From: Ian Stocks [REDACTED] **On Behalf Of** FRS Water and Access
Sent: 06 August 2021 11:17
To: Michael Eastham <Michael.Eastham@arun.gov.uk>
Subject: RE: WA/63/21/PL - Land East of Tye Lane, Walberton

Please could you submit your consultation response to planning application **WA/63/21/PL** for Land East of Tye Lane, Walberton.

I would really appreciate your comments on the proposed emergency access onto Avisford Park Road.

VIEWPORT 4 - PROPOSED EMERGENCY ACCESS AT AWISFOD PARK ROAD

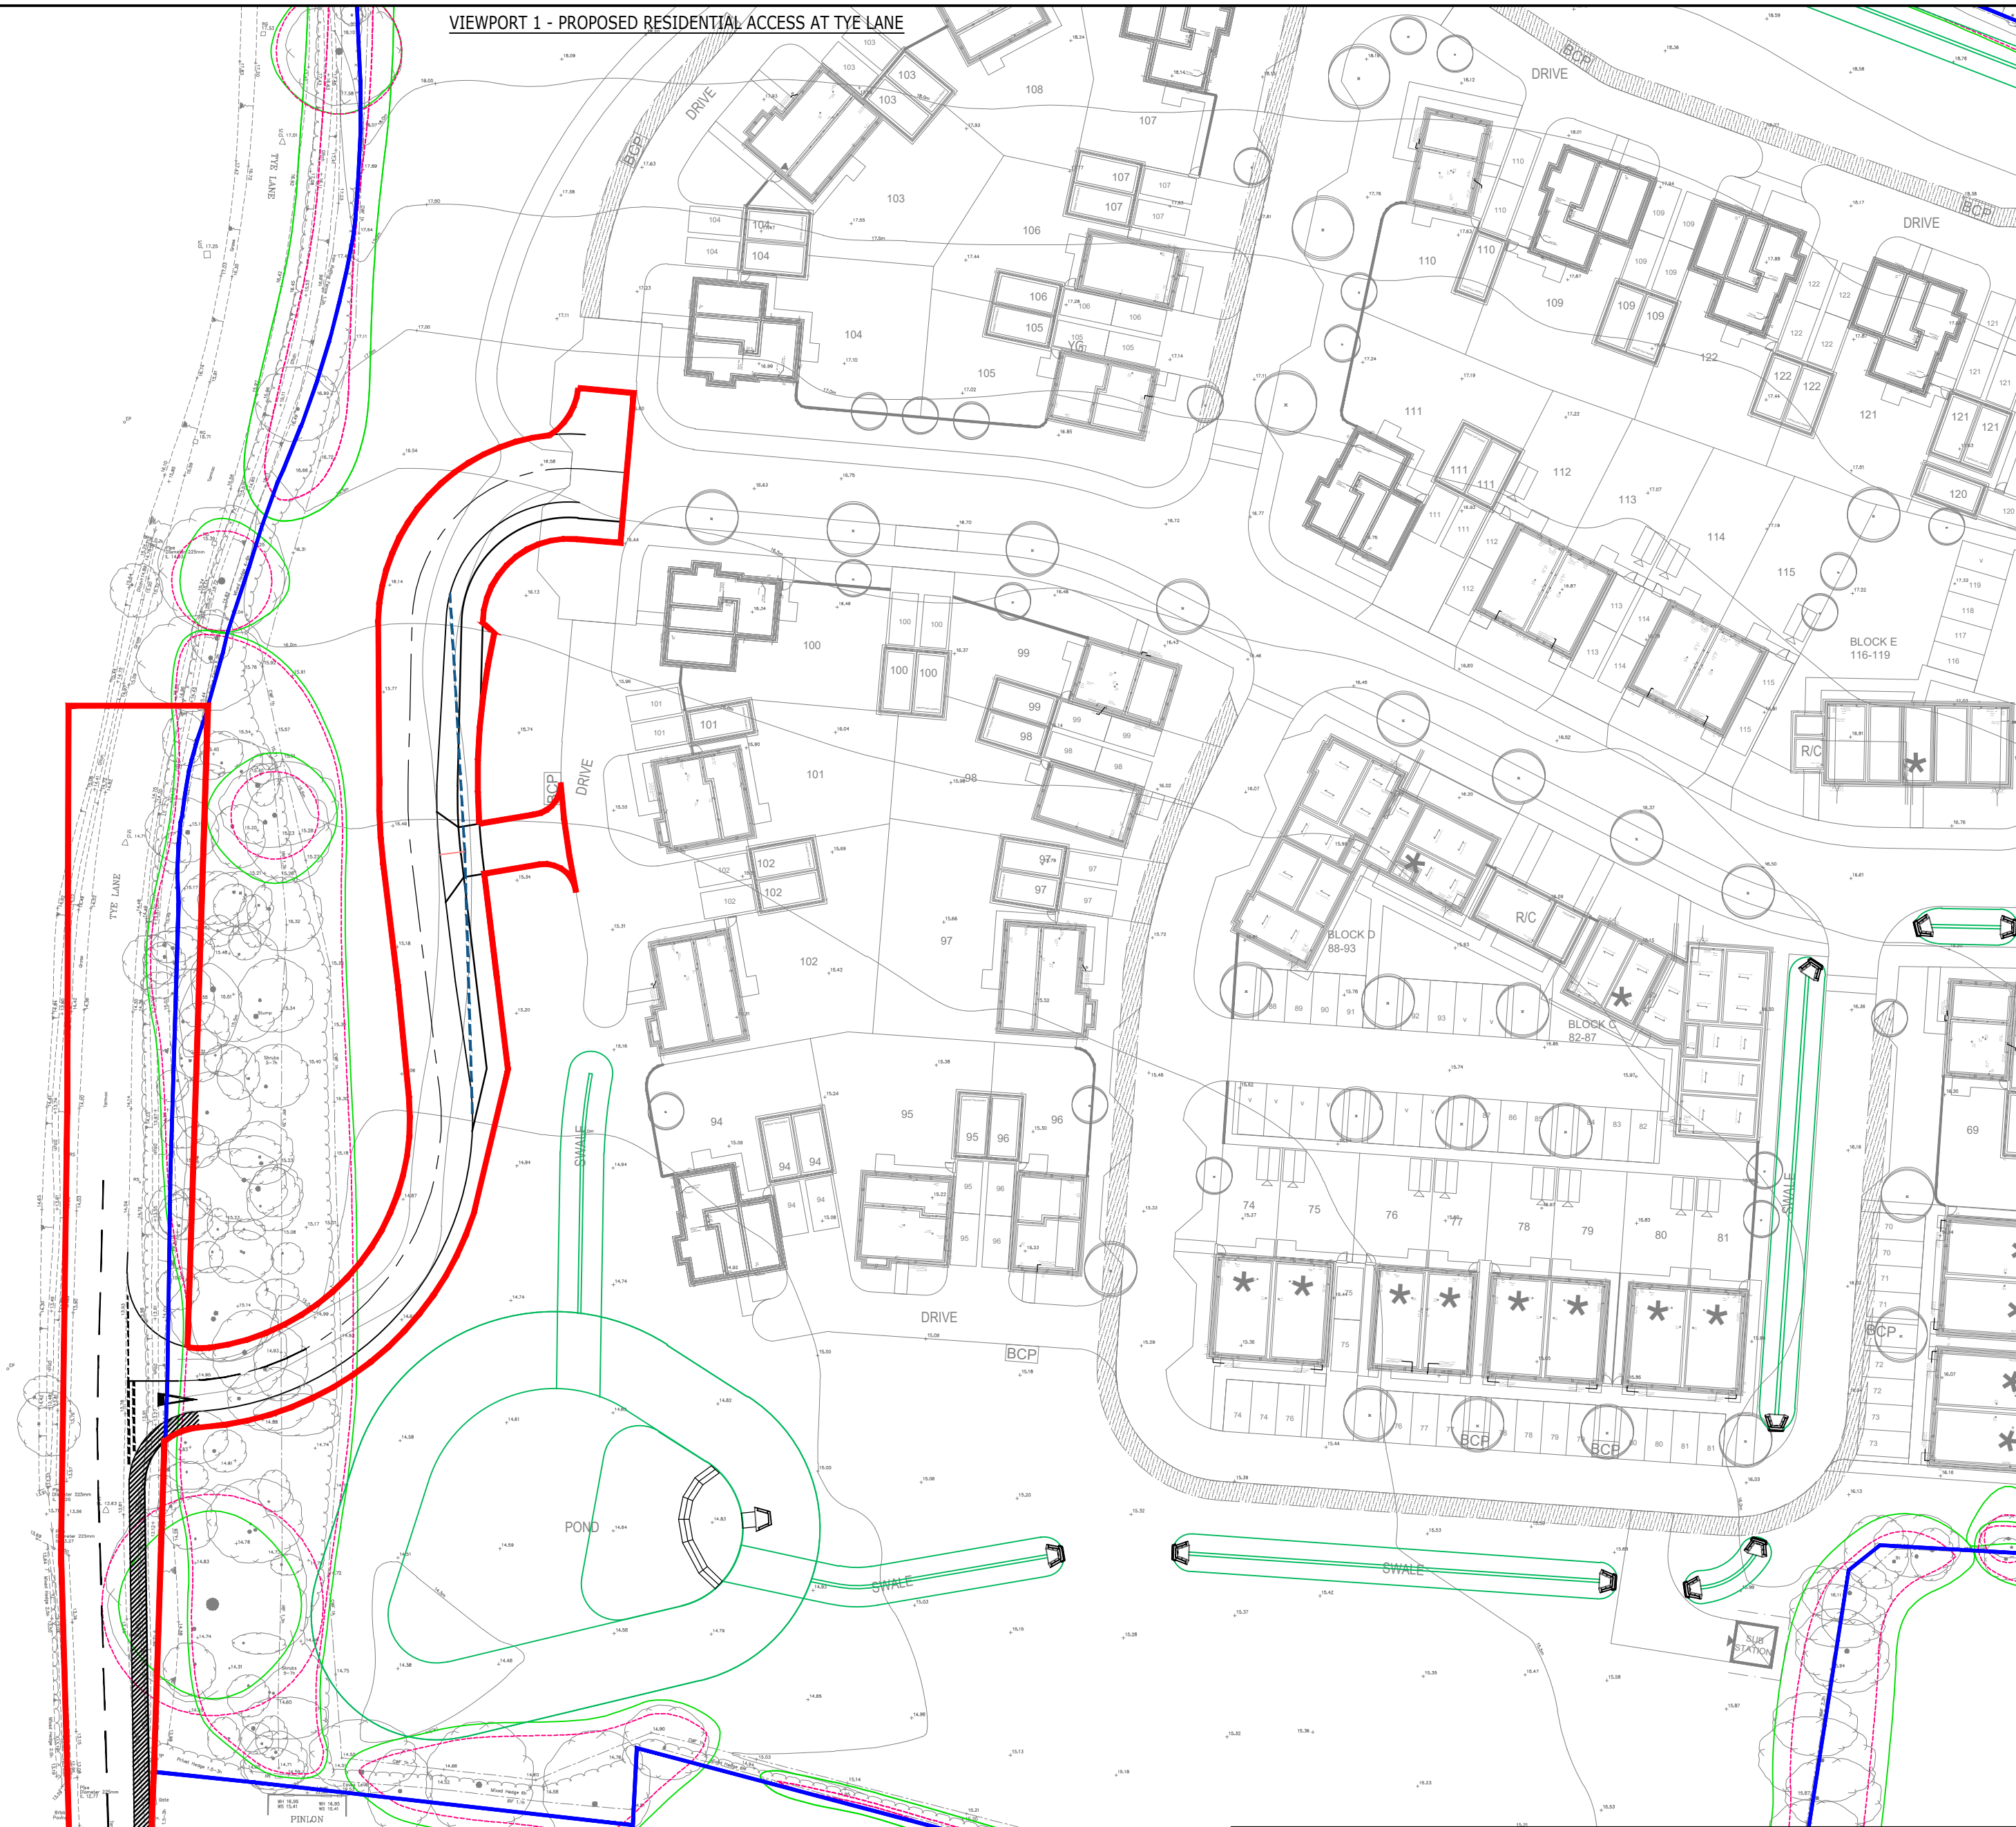
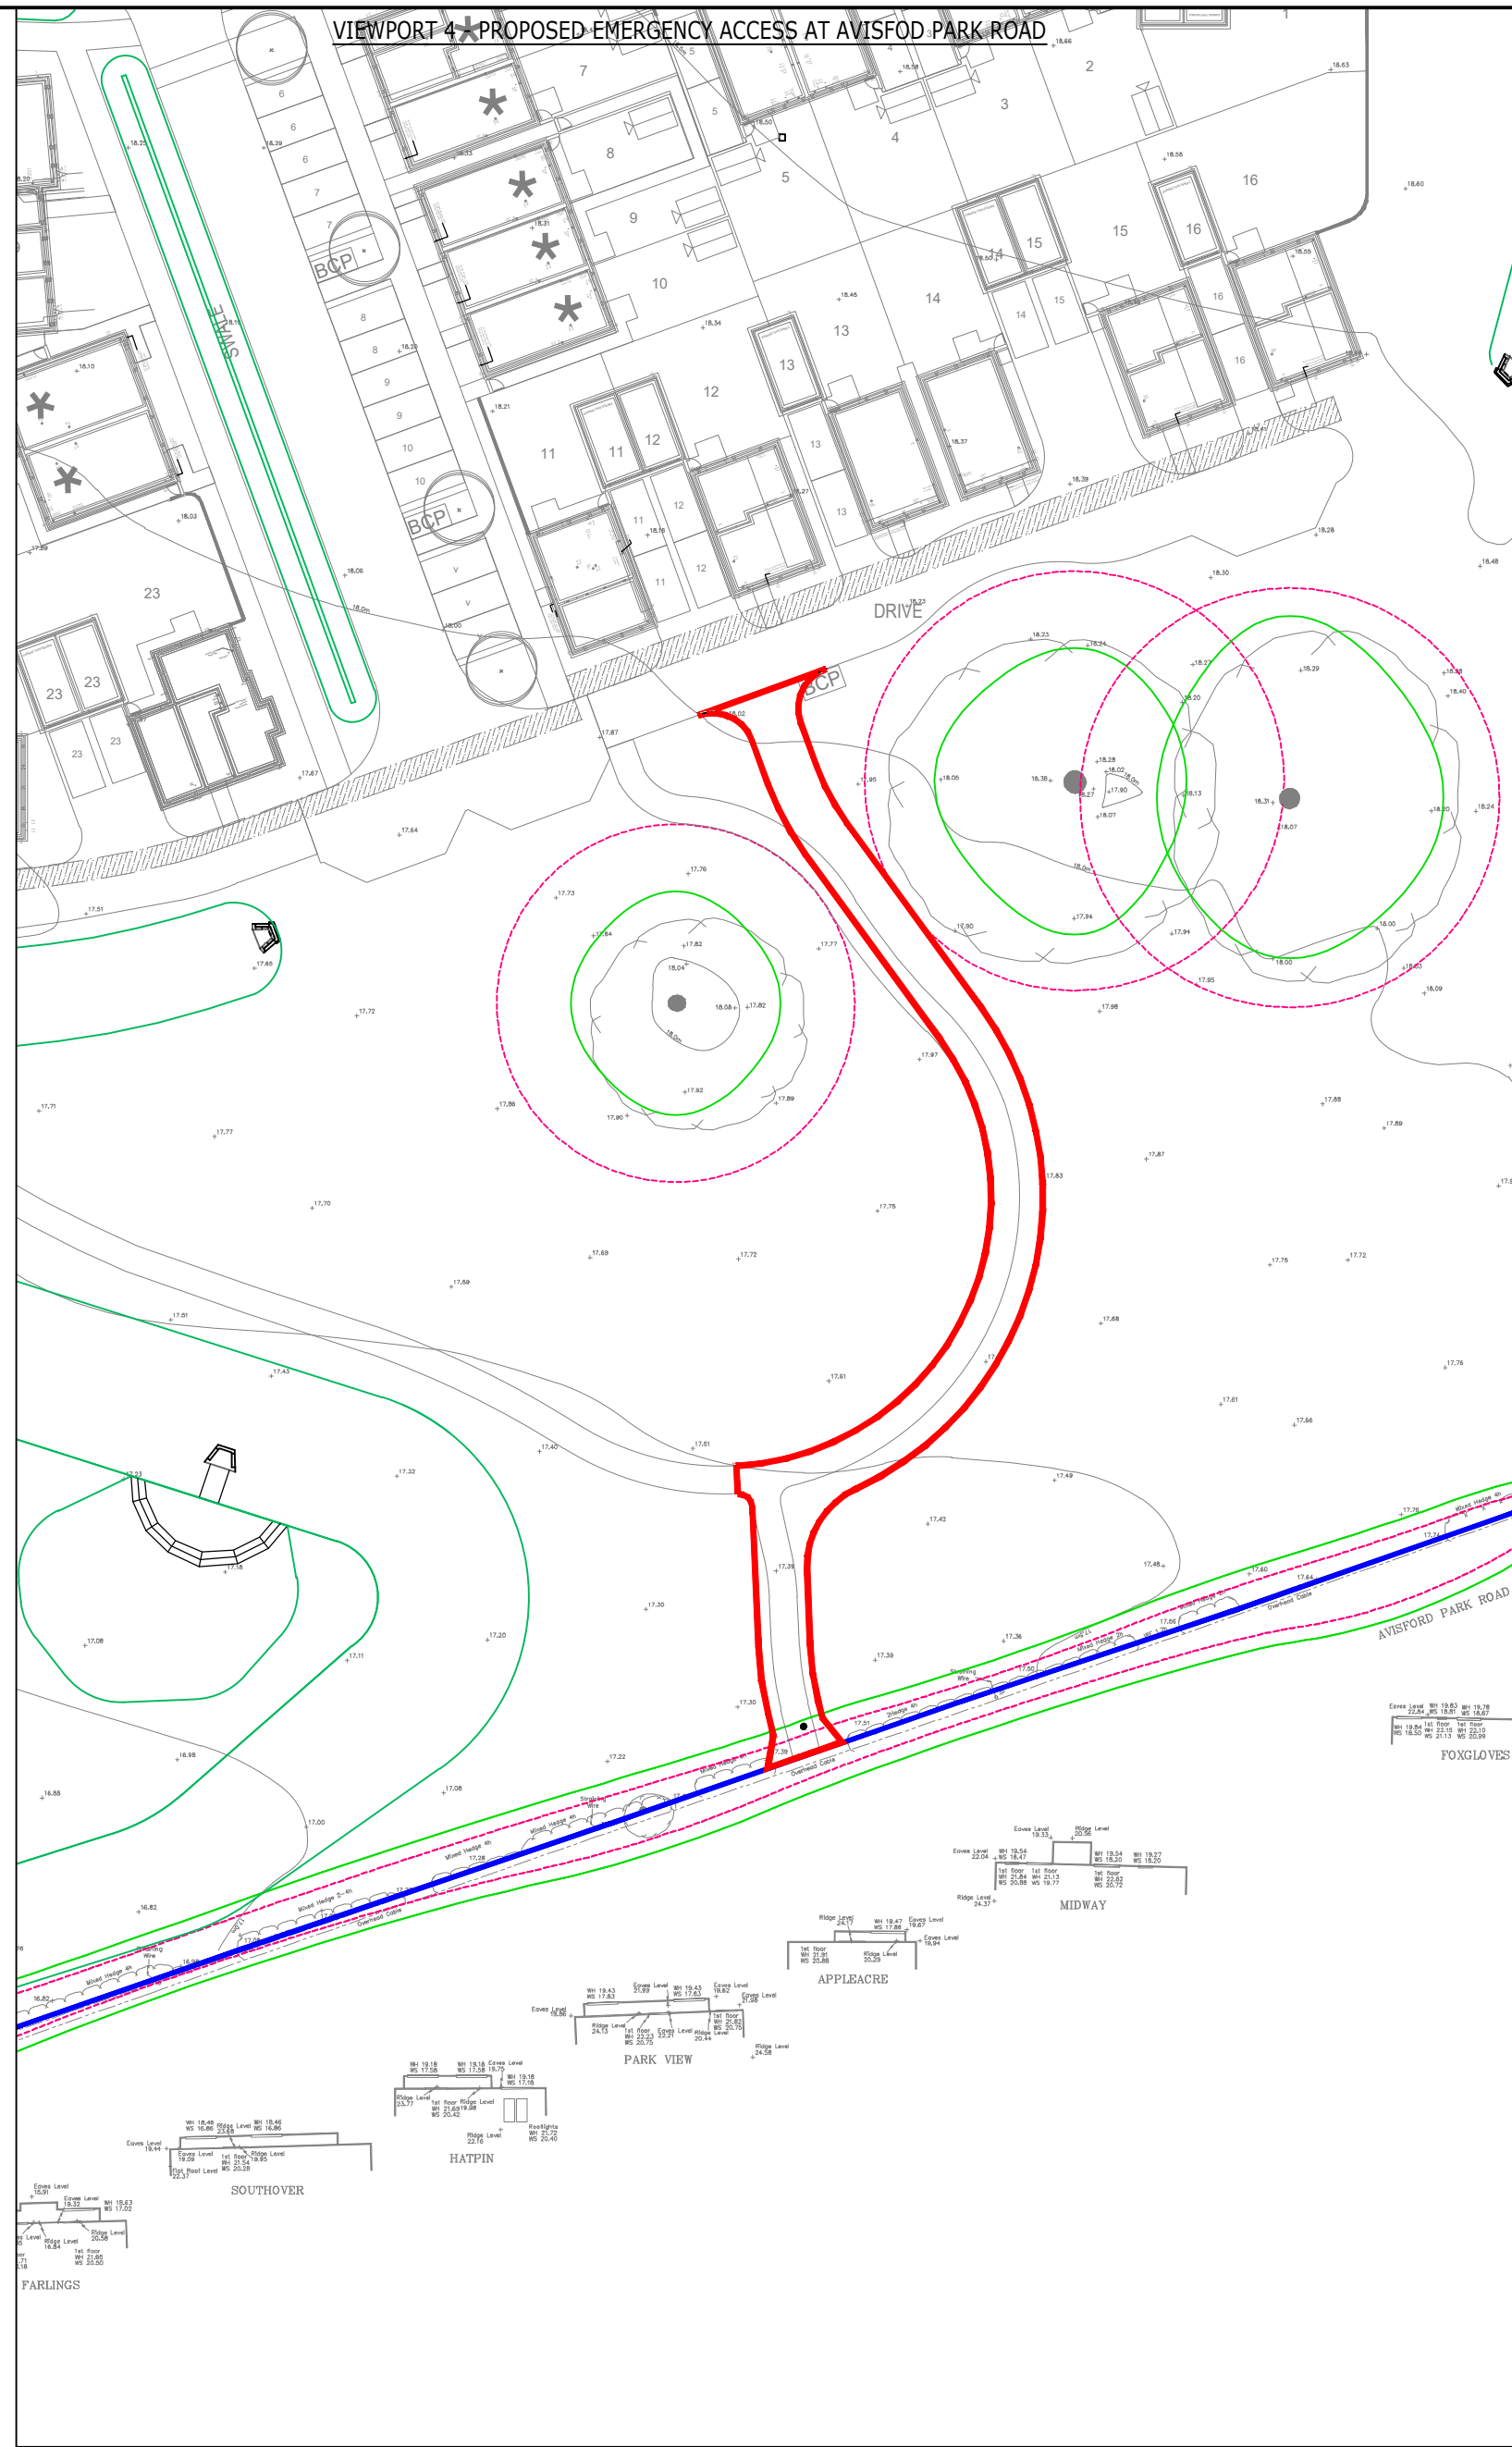
Having viewed the plans for the application given above, providing the access routes comply with the requirements of Approved Document – B 2019 edition: B5 section 13, the application would be considered acceptable by West Sussex Fire & Rescue Service. A suitable control measure will need to be put in place for the removal of the bollards should the emergency access route need to be used.
